# CITY OF ALBUQUERQUE

**RE: Ventura Plaza - Parcel A-1 (Christian Brothers Automotive)**  
**Grading Plan**  
**Stamp Date: 7/28/17**  
**Hydrology File: D20D010B**

Sheet Title:  
GRADING AND  
DRAINAGE  
MANAGEMENT PLAN

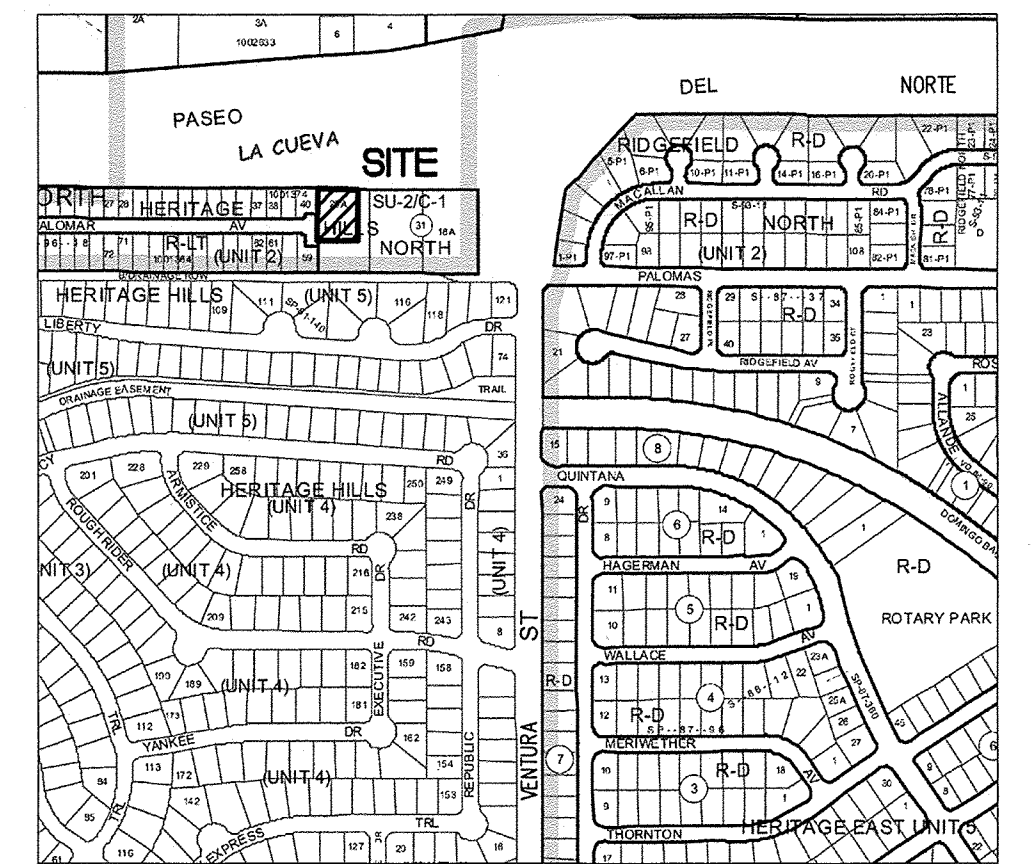
1. Please change the sheet title to "Conceptual Grading Plan" and add a note stating "Not for Construction". Please resubmit this Conceptual Grading Plan to the DRB.
